HOUSEHOLDER PLANNING APPLICATION

REF: AB/76/21/L and AB/75/21/HOU

RE: 54 TARRANT STREET . ARUNDEL BN18 9DN

SCHEDULE OF CONDITION OF EXISTING WINDOWS AND
PROPOSED WORKS OF REPAIR AND/OR REPLACEMENT:

REPLACEMENT, ALTERED + NEW WINDOWS  
54 TARRANT STREET, ARUNDEL

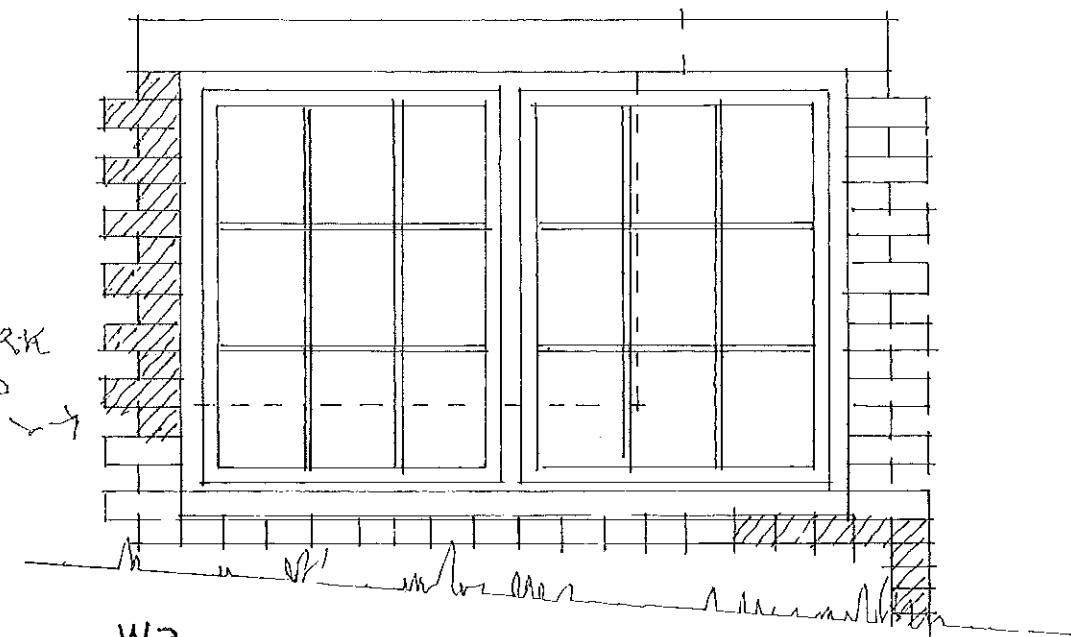
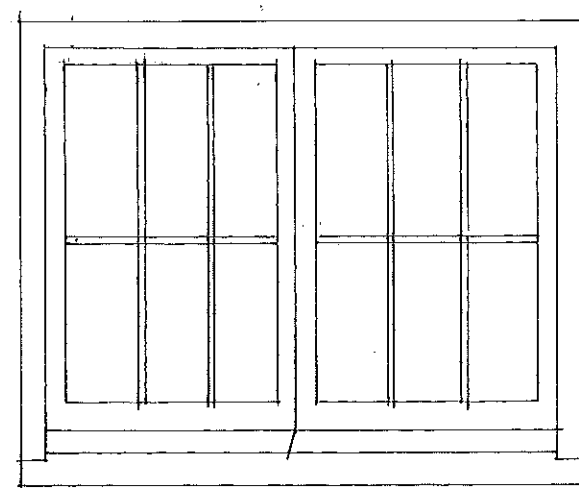
W1A RENOVATE existing unglazed window and replace oak lintel over

W1B NEW inward opening, inner oak window behind existing unglazed window. Double glaze.

W2 All NEW in new opening. Frame and glazing bars to match W3.

W3 Existing opening to be enlarged. Original frame totally rotten and was removed. Sections kept for reference for matching.
All NEW

W4 Existing timber louvres to be replaced with new glazed top hung inward opening frame. Toughened glass due to location.

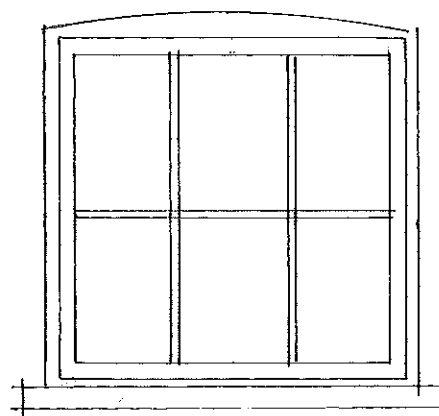
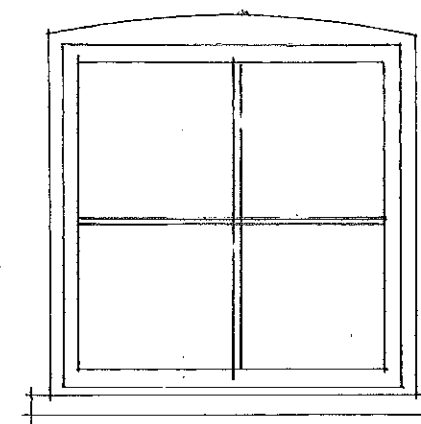
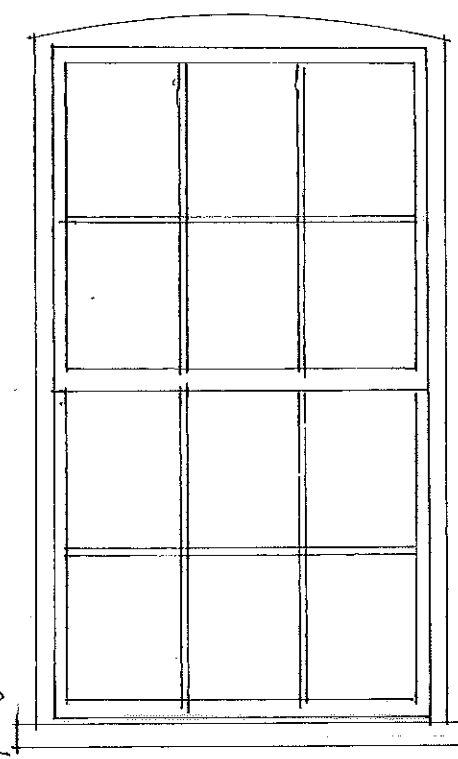
W5. Repaired within the last three years but filling and piecing in is extensive and beyond further repair.
REPLACE frame, cill and casements, glaze with acoustic reducing and toughened glass due to location.

W6 Rot in box frames and under cill and bottom of sashes.
REPLACE to match existing, add slim line double glazing.

W7 Rot in box frames, cill and sashes.
REPLACE to match existing, add slim line double glazing.

W8 Rot in box frames and under cill.
REPLACE to match existing, add slim line double glazing.

W9 Rot in box frames, cill and sashes.
REPLACE to match existing, add slim line double glazing.

W10. Rot in and under cill.
REPAIR sashes REPLACE cill.

W11. Rot in bottom corners of frame and parts of sashes.
REPAIR

W12. Rot in box frames, cill and bottom of sashes.
REPLACE to match existing.

W13. Rot extensive to frame and sashes, previously repaired but now beyond further repair. NOTE: West facing.
REPLACE frame, cill and sashes to match existing refit existing glass.
